**Submission for State Significance Development - SSD 17- 8699**

**Greenwich Hospital  
97-115 River Road, Greenwich, 2065  
Lane Cove Municipal Council**

DRAWING TITLE:
SITE SECTIONS
DATE:
AUGUST 2019
DRAWN:
ML, JC
PROJ:
1213
PROJ ARCH:
BF
DRAWING:
S.04a
SCALE:
As indicated @ A1
REVISION:
P5

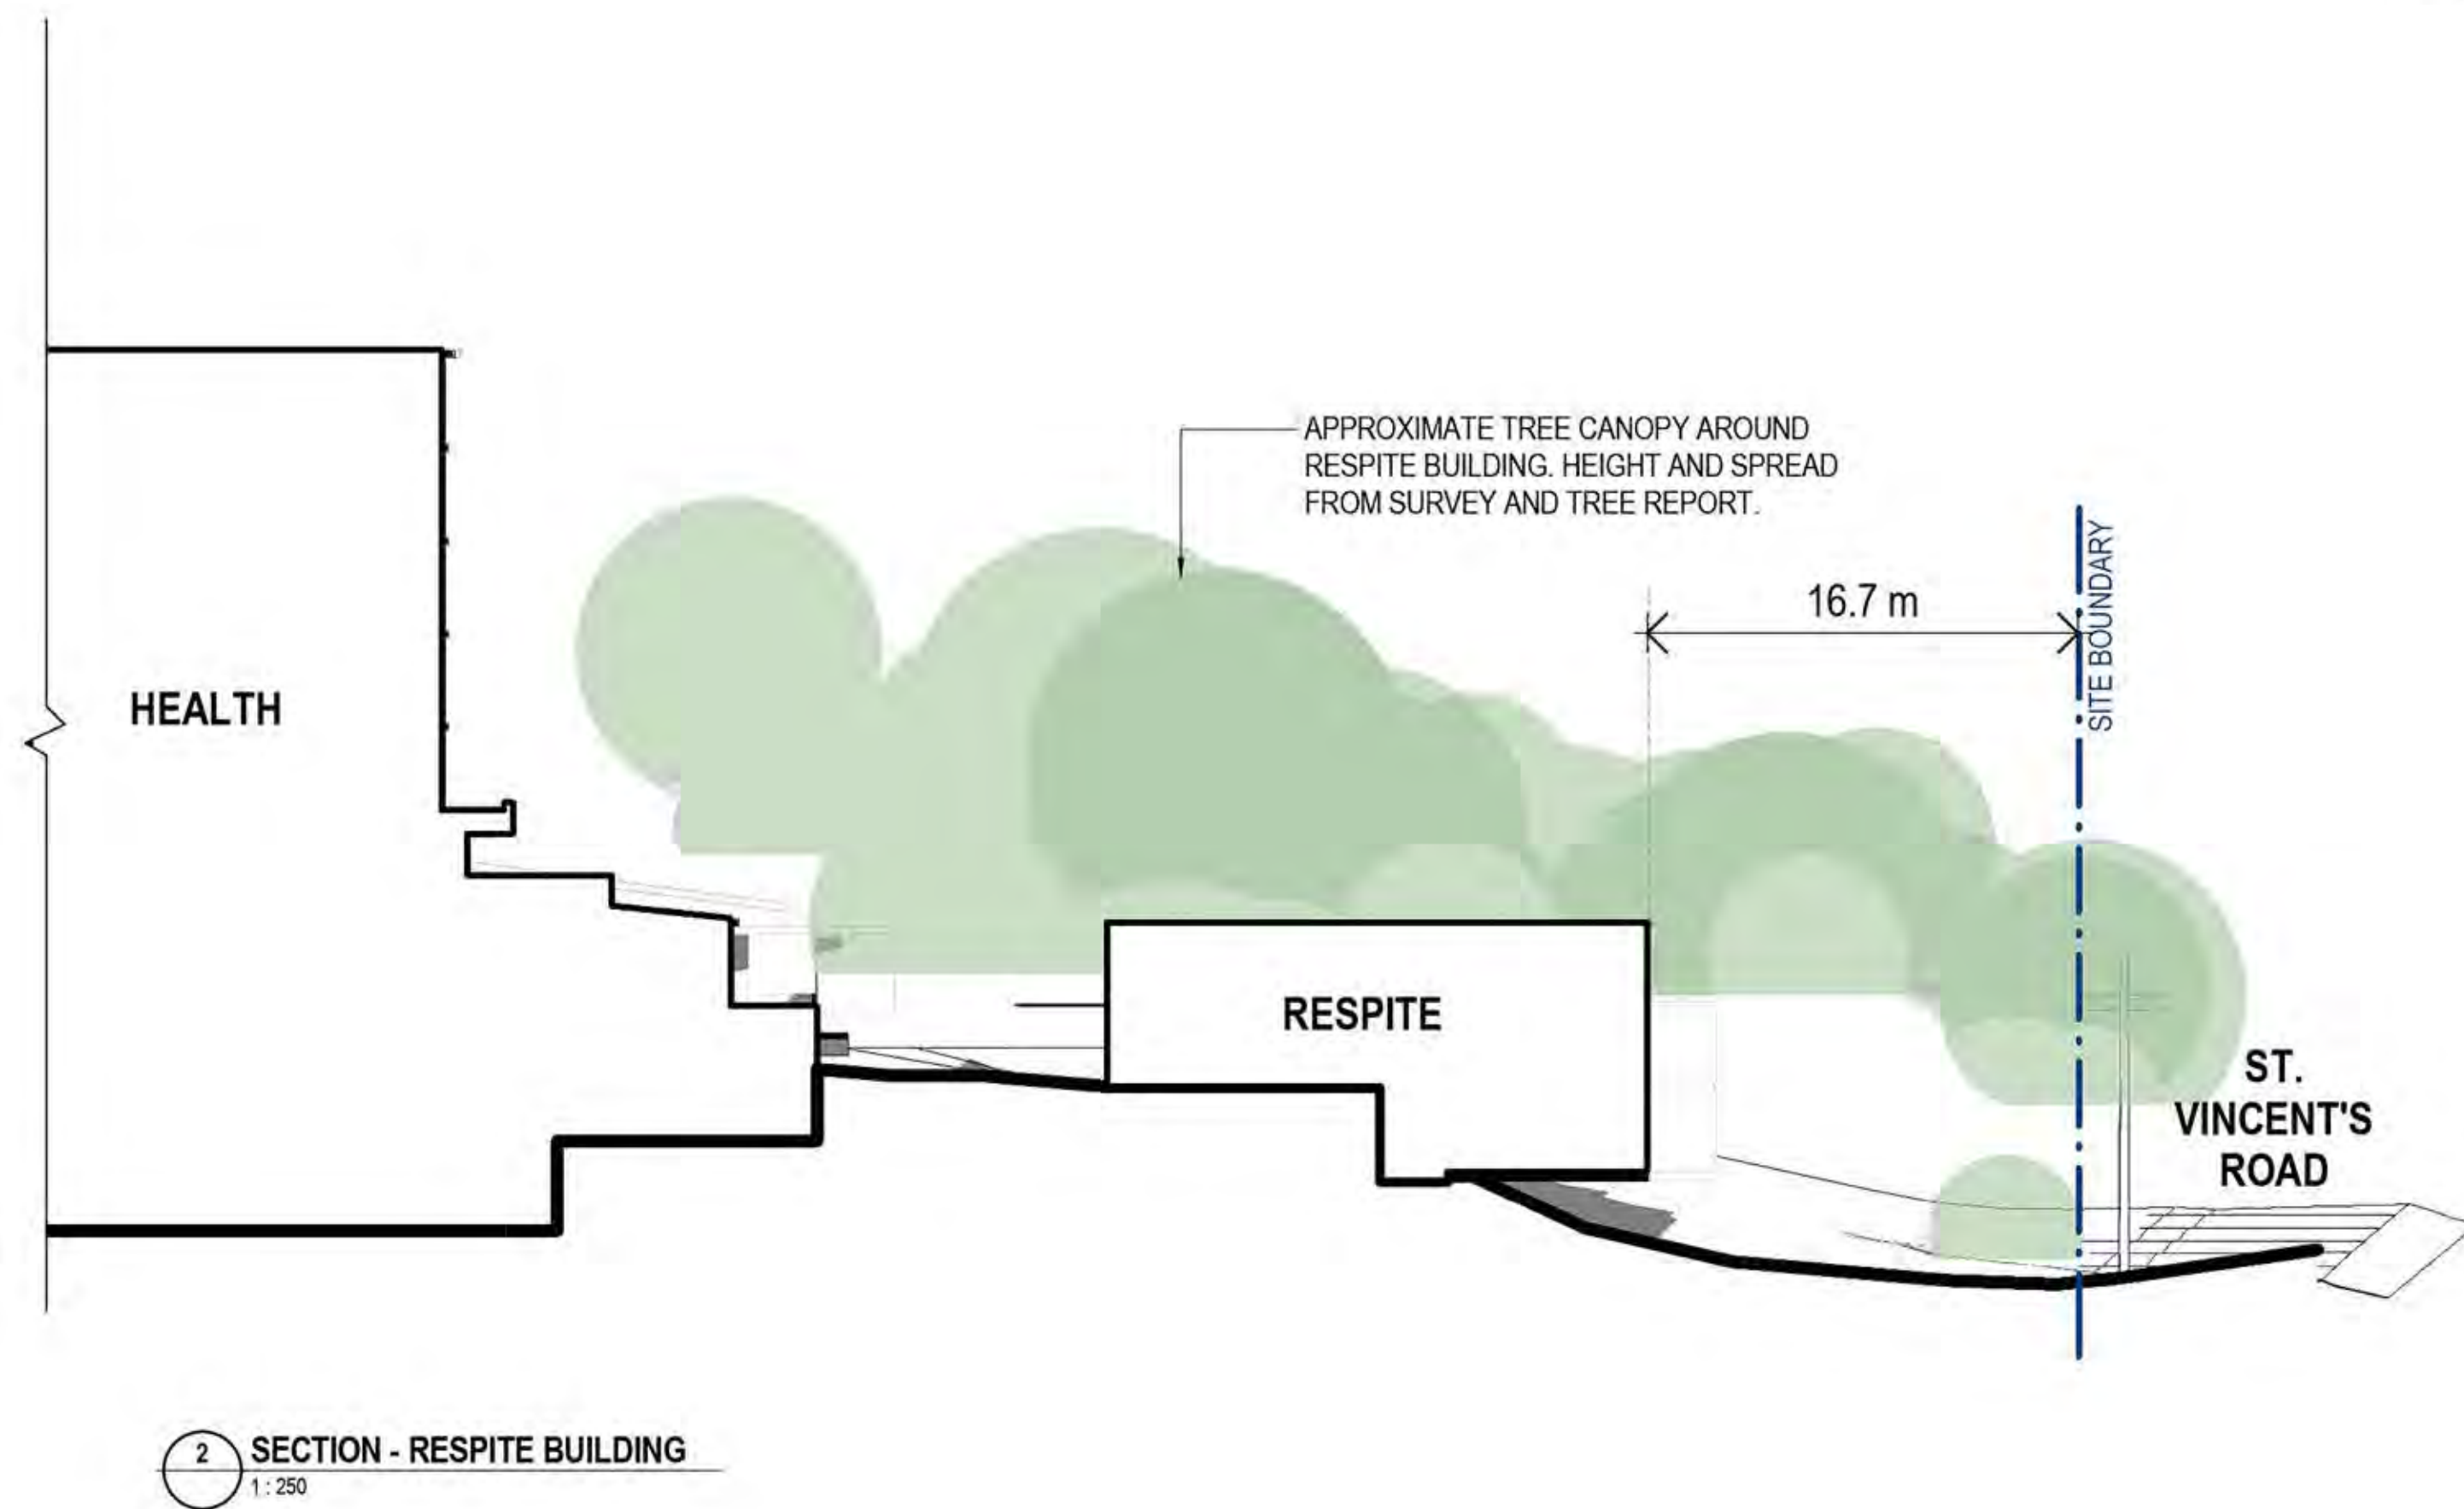
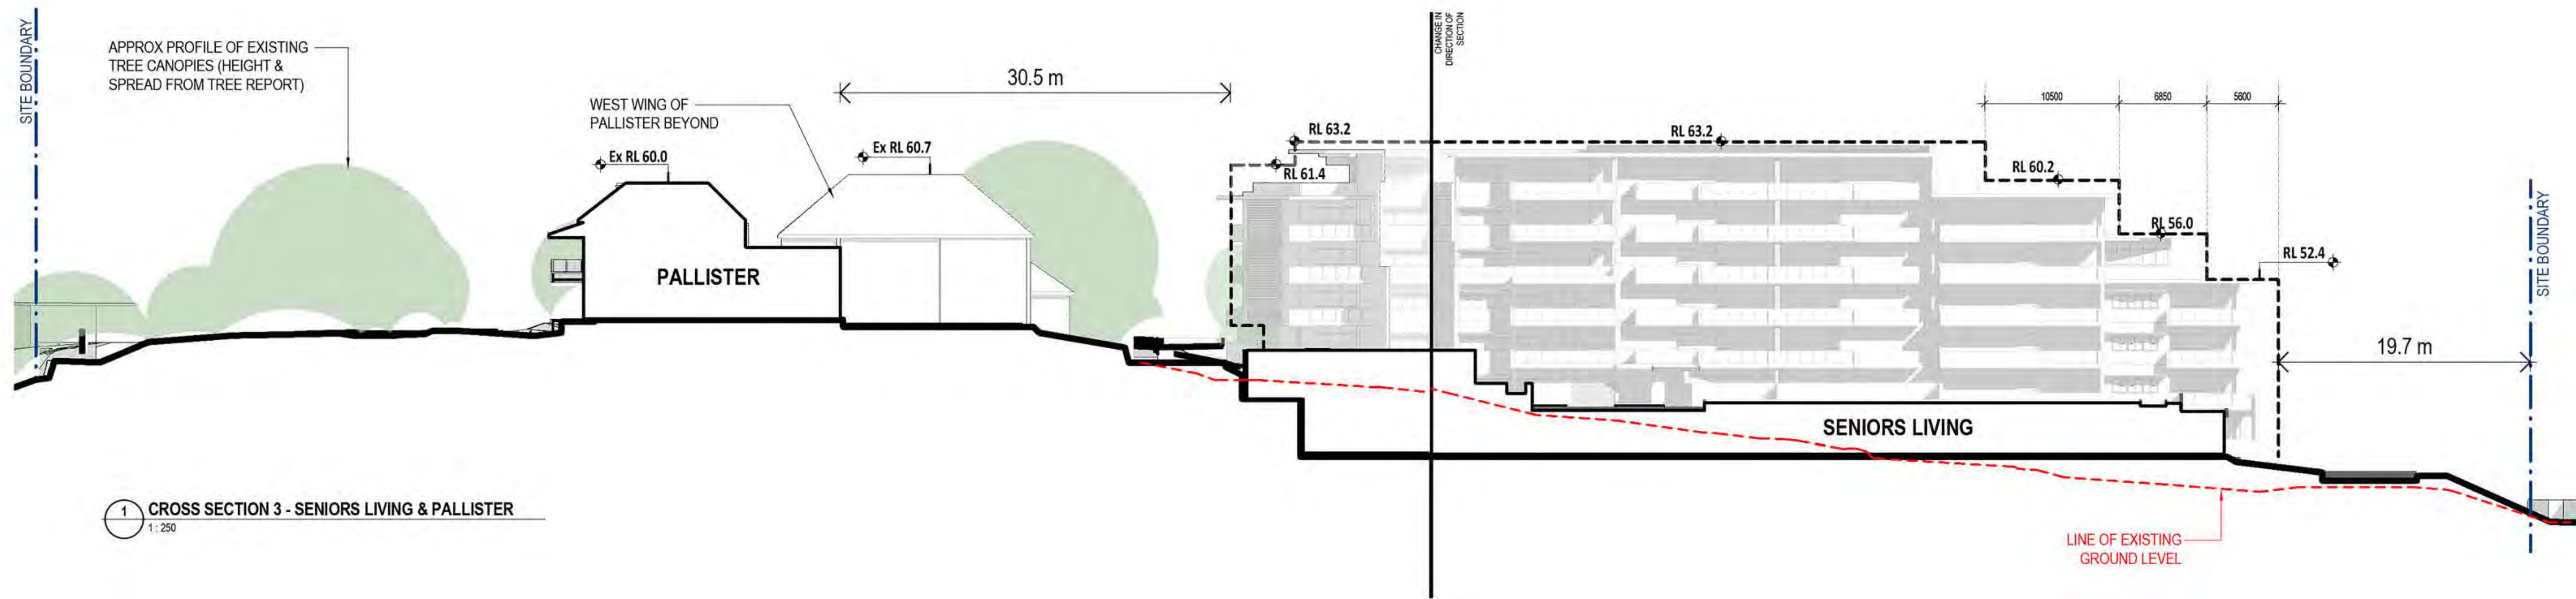
The three articulated tower wings, even with set back from the Podium edge do not mitigate the visual impact of the structure but in fact contribute substantially to the impact to the extent that the heritage item will not be appreciated in its own setting. The proposed Hospital building will be in very close proximity and will encroach and visually dominate Pallister House.

DRAWING TITLE: EXISTING TREES		DATE: AUGUST 2019		DRAWN: EC		PROJ ARCH: BF		SCALE: 1: 500 @ A1	
				PROJ: 1213		DRAWING: S.10		REVISION: P5

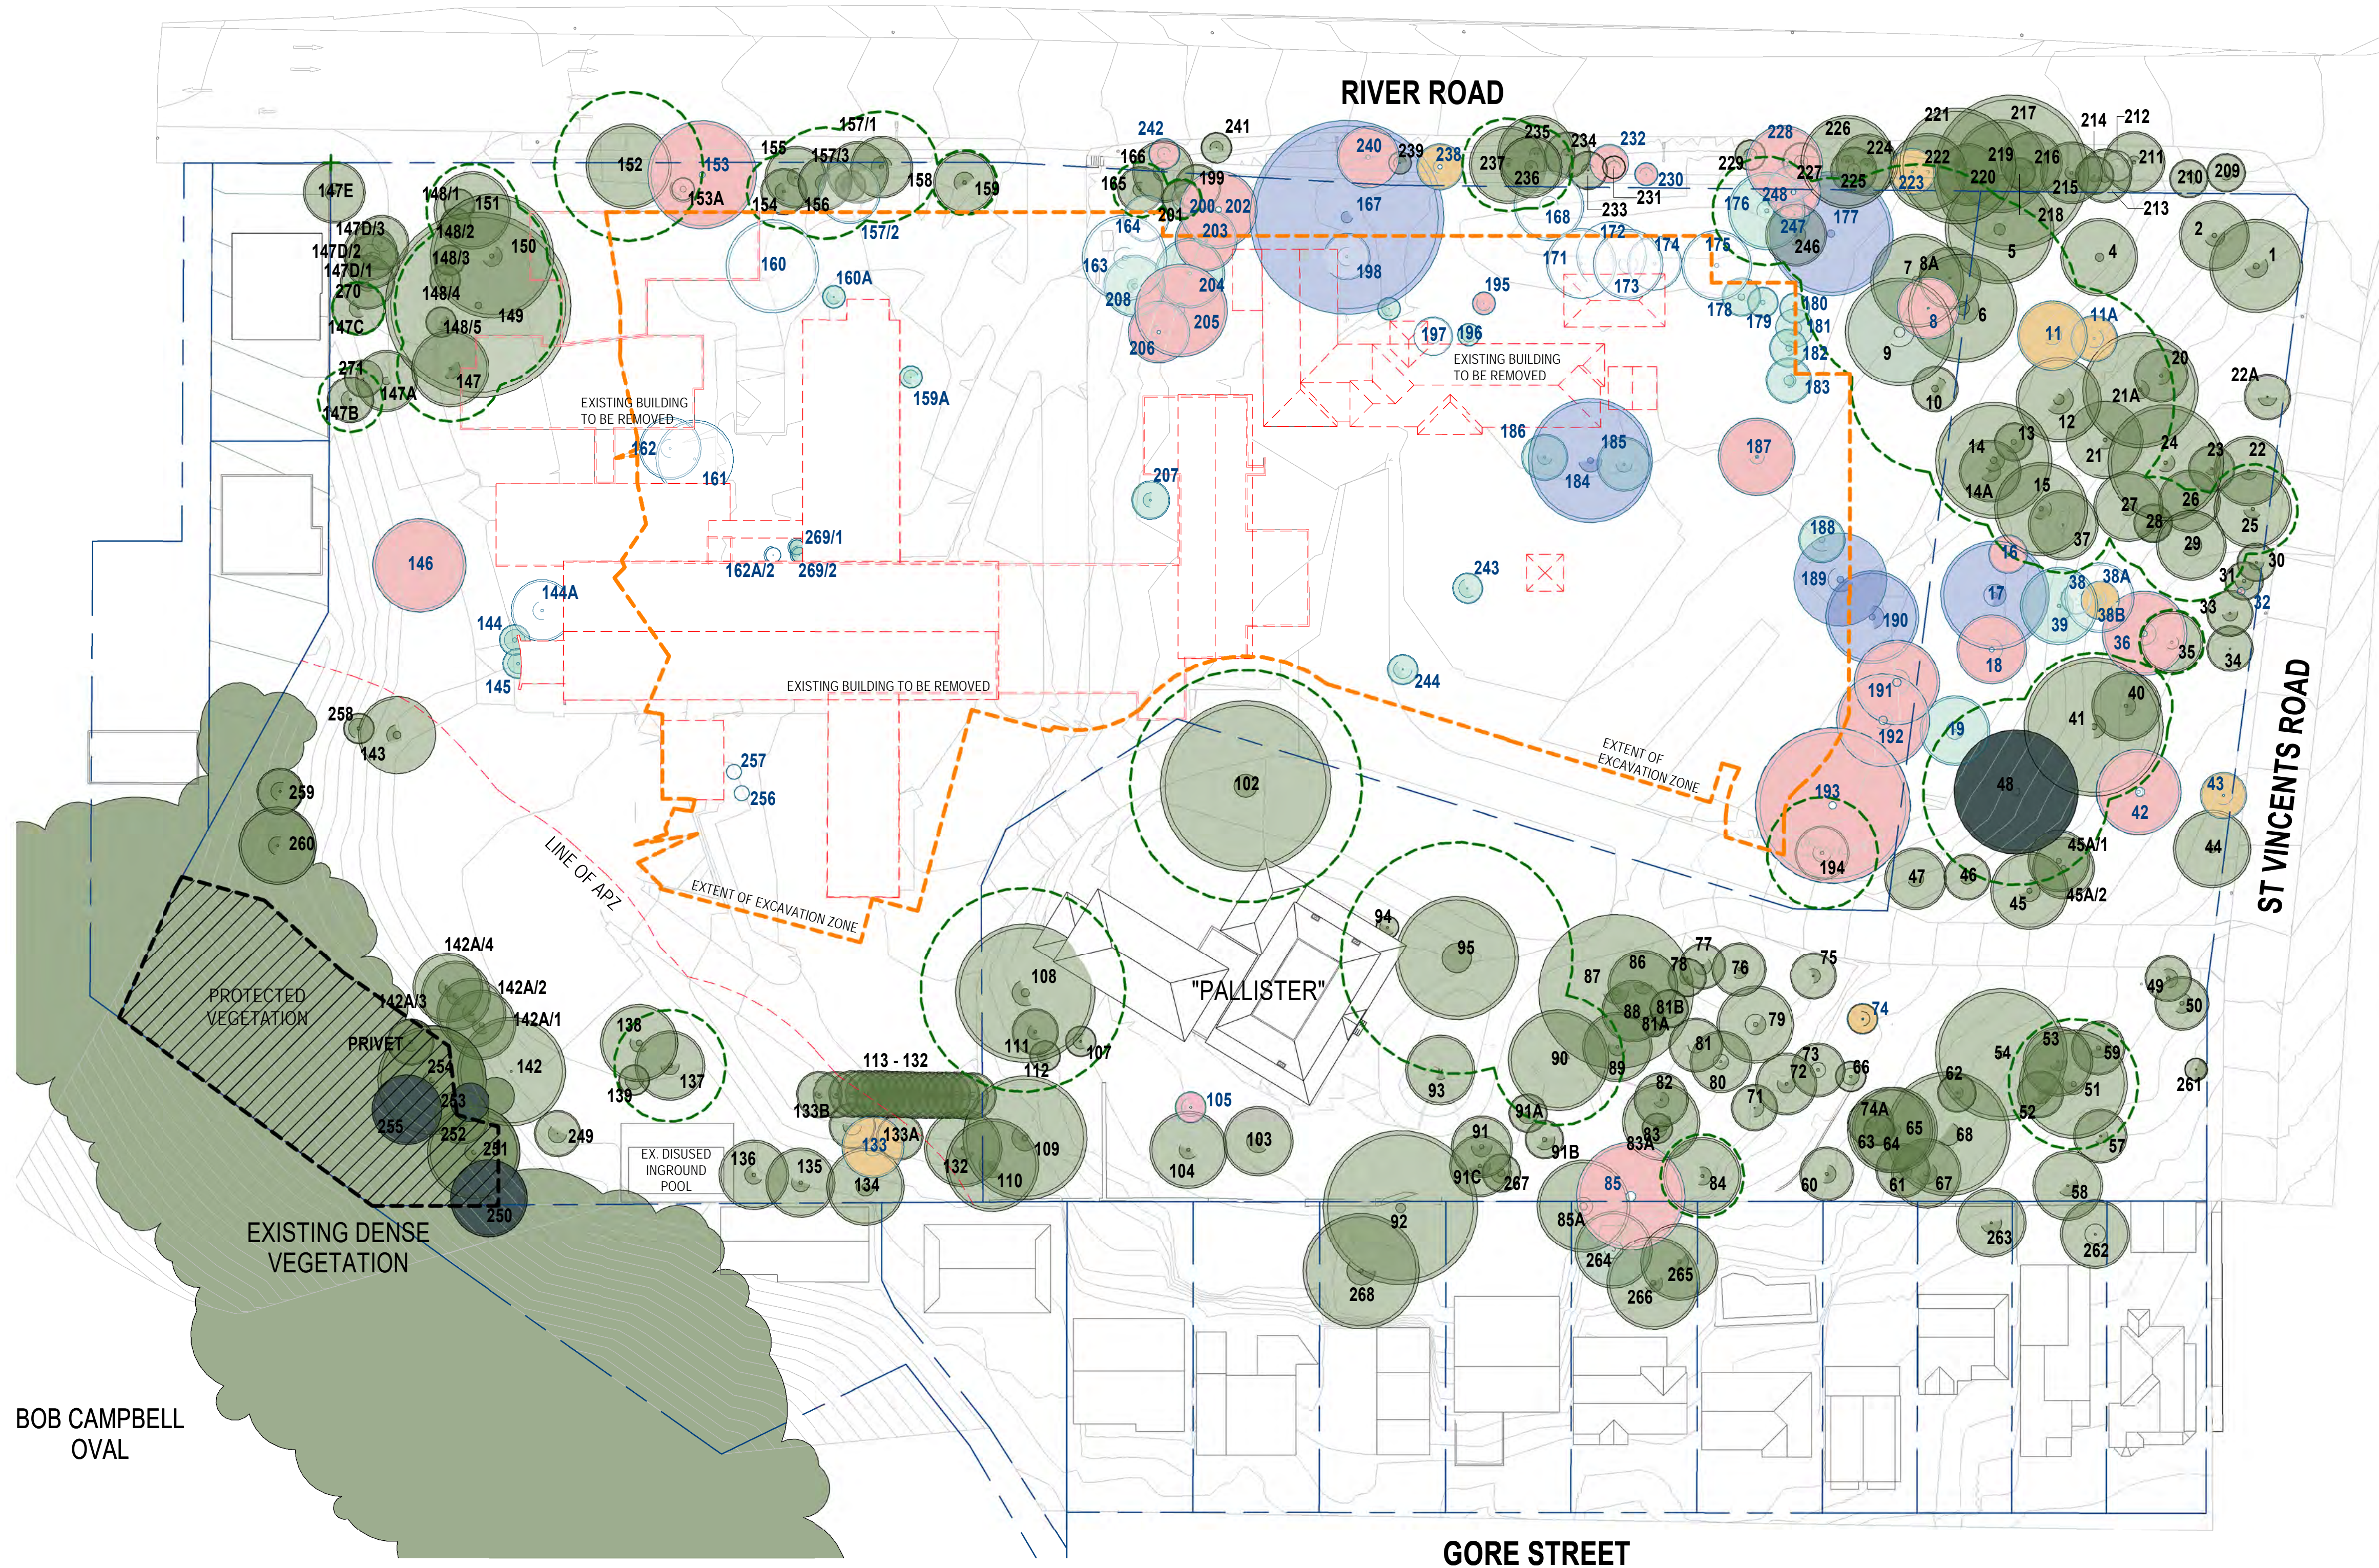
There is a large loss of number of mature and attractive trees which is unacceptable. There is no need to take out so many trees and the only reason is to have the ability to build more residential units. The loss of trees for the area is not acceptable. This can be seen from the picture below.
